Date: 06/10/2024

Re: **Footing Projection Issue**
Location: Lot 52 Magnolia Acres (72 White Magnolia Lane Fuquay-Varina, NC)
JDS Project No.: RDU2405923
Date of Inspection: 06/10/2024

SHEET: 4 OF 39
 S-1.1d
 CRAWL
 FOUNDATION PLAN

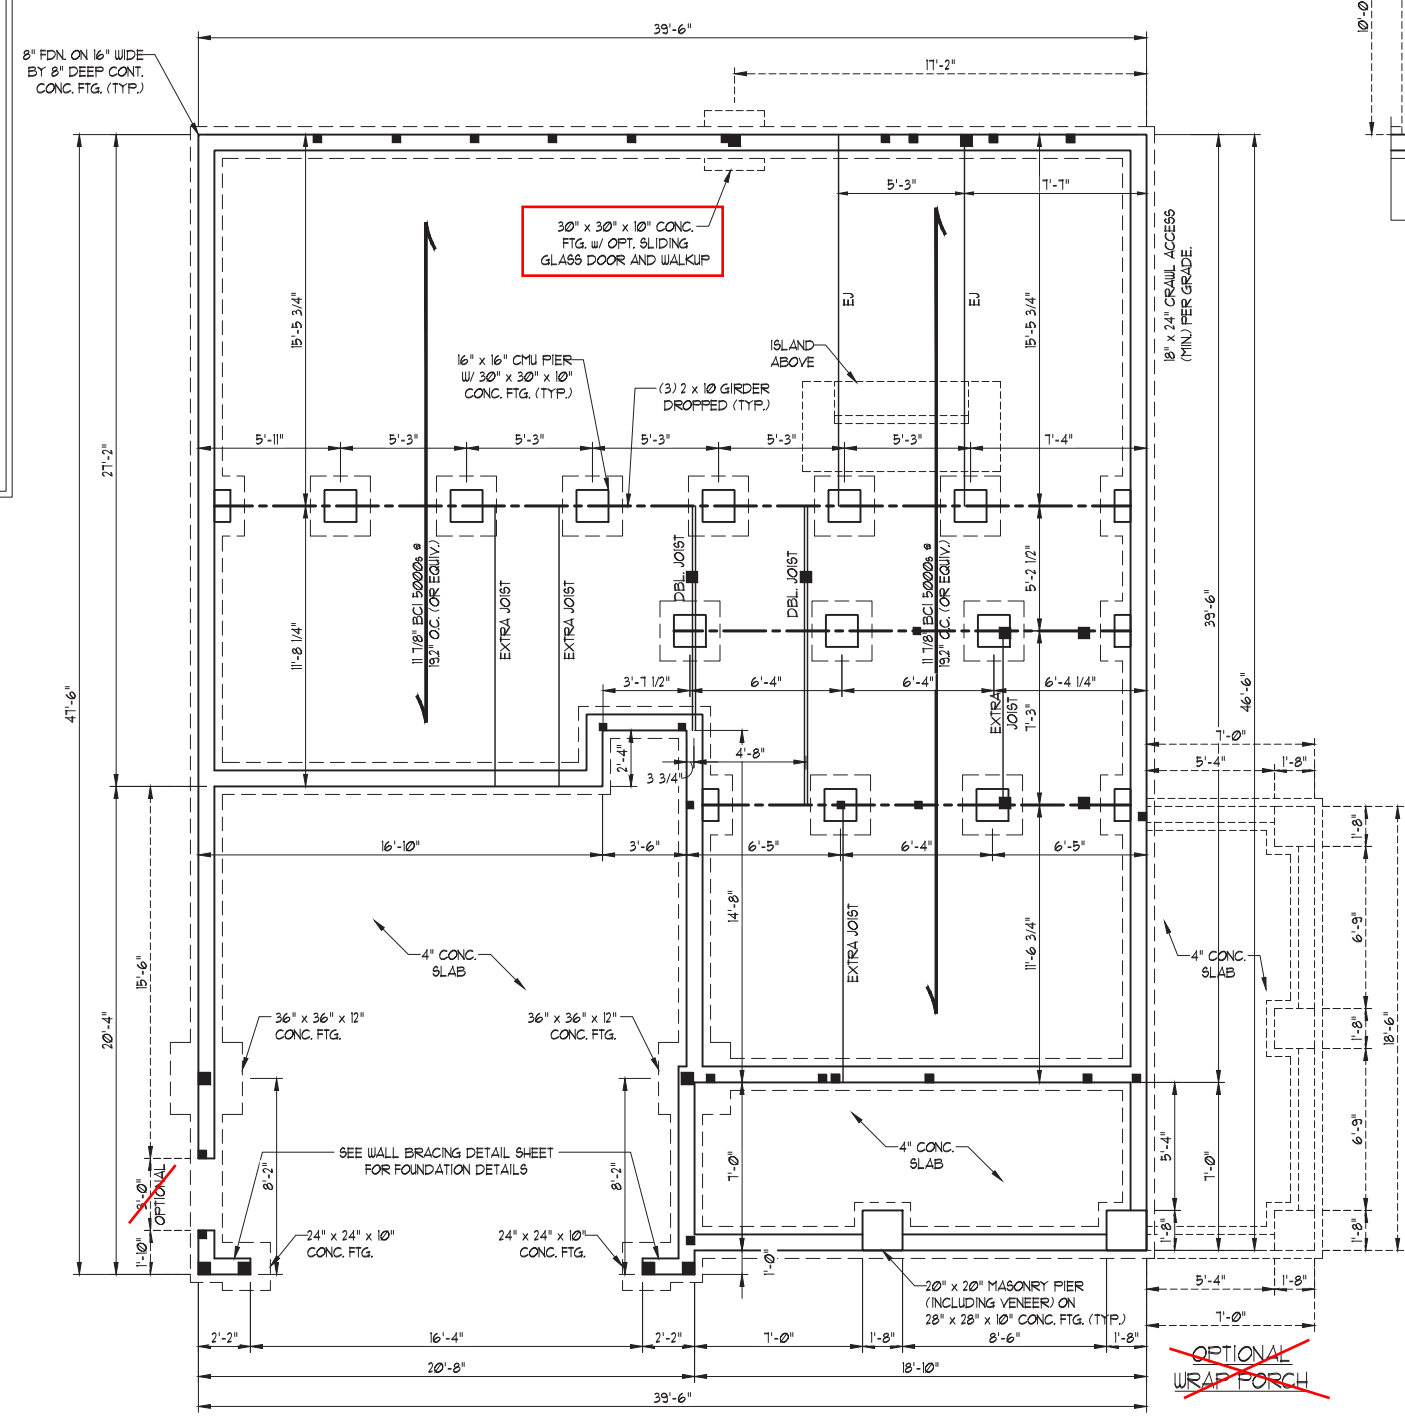
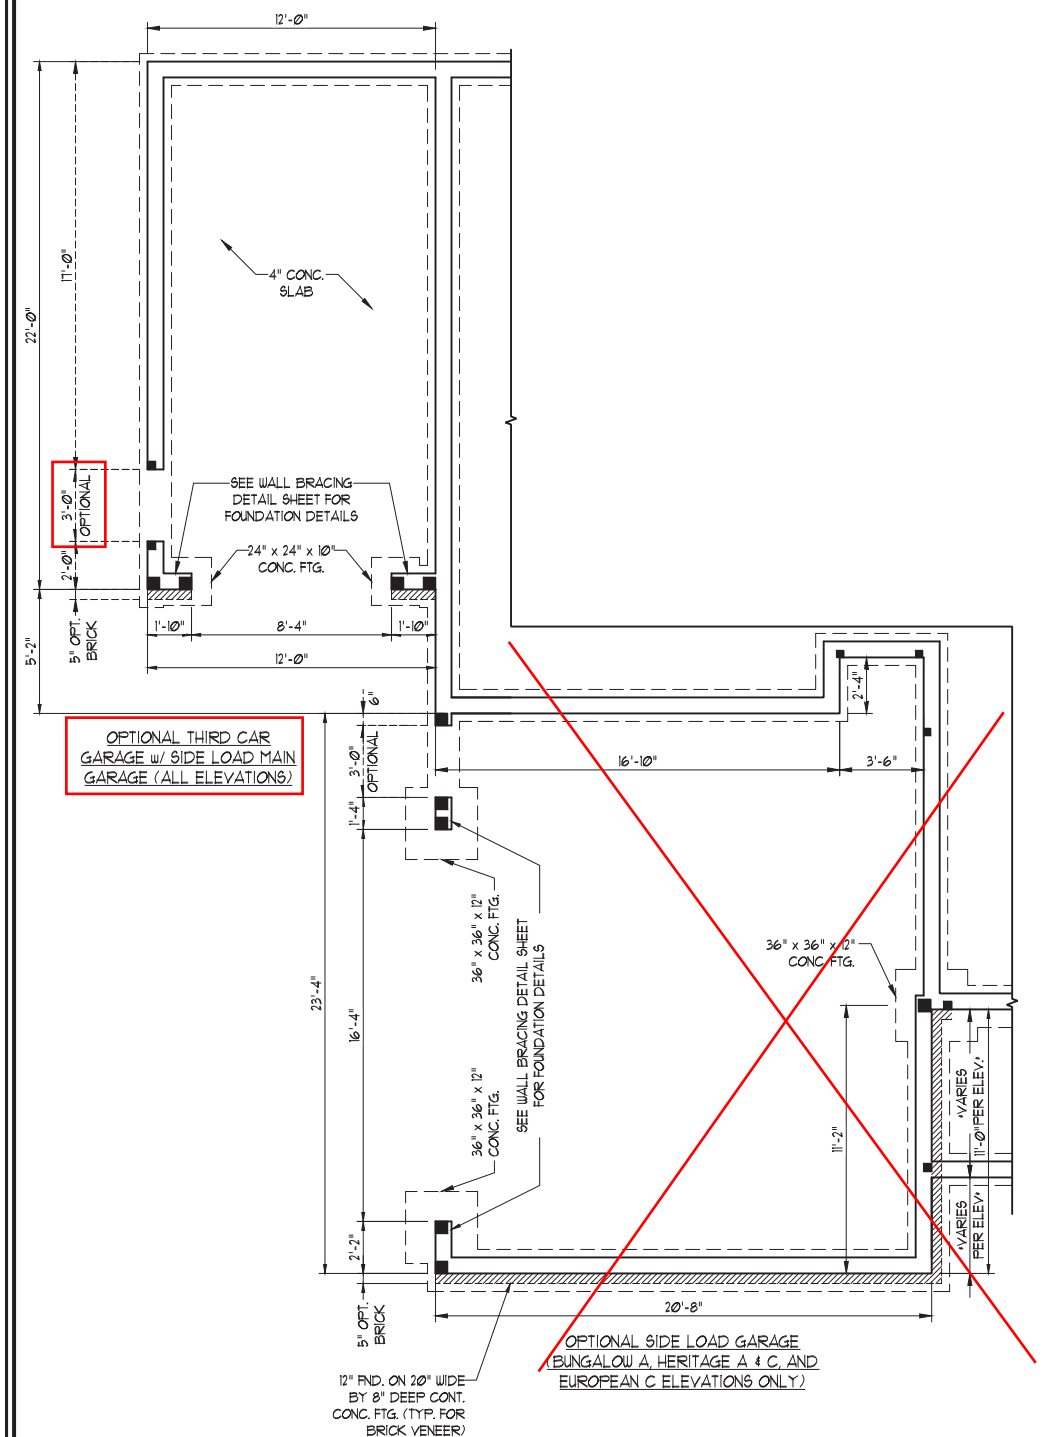
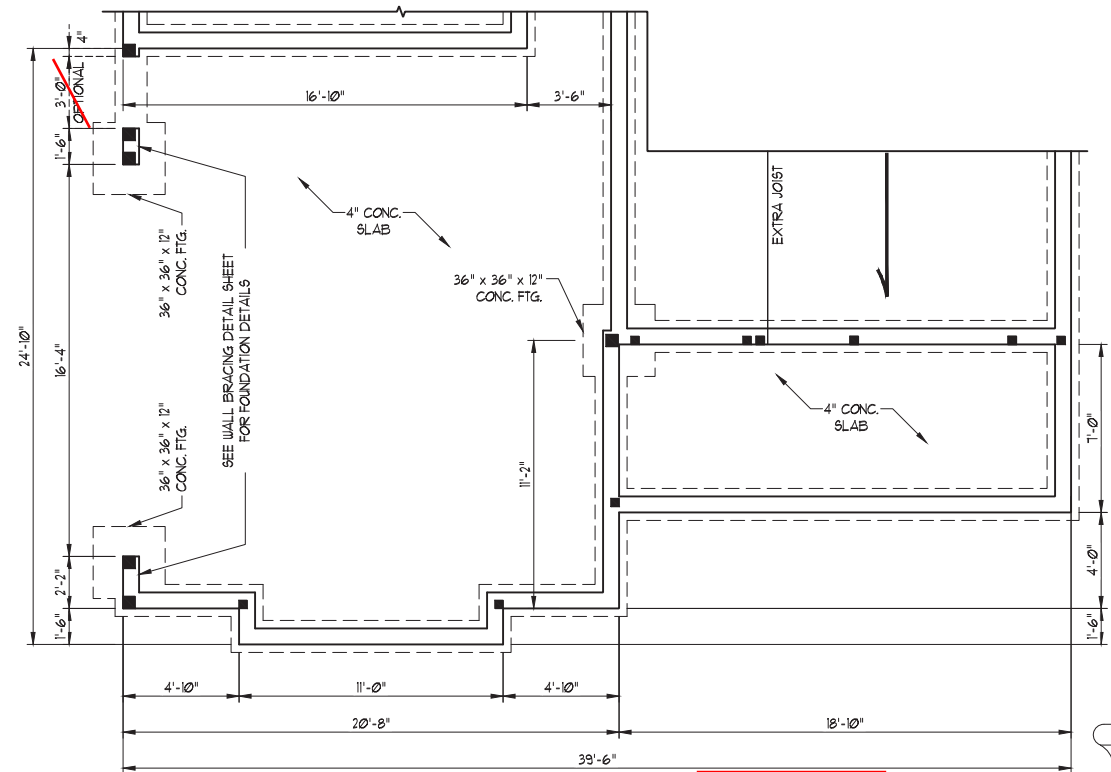
The client requested an evaluation of (2) piers located along the right wall, 1st and 2nd from the rear wall. The plans called for the piers to be 16" x 8". Due to the height, they were made 16" x 16", not giving them minimum 2" projection on the left side.

Based on our observations and review, Extend the footing at the left side of the footing per these steps:

1. Excavate all fill at the left side of the footing the full depth, and a minimum of 8" from the face of the existing footing to be extended.
2. Dowel (3) #4 rebar equally spaced into the left face of the existing footing. Dowels should be placed at least 4" into footing and extend 4" into a newly excavated footing. Penetrations into concrete should be cleaned with compressed air and/or wire brush and the dowels should be installed into the existing footings using enough epoxy to be seen seeping out of the holes. Provide 3" minimum of clear cover for all rebar.

Before placing a minimum of 3,000 psi concrete, the client shall insure the repair preparation has been inspected and approved.
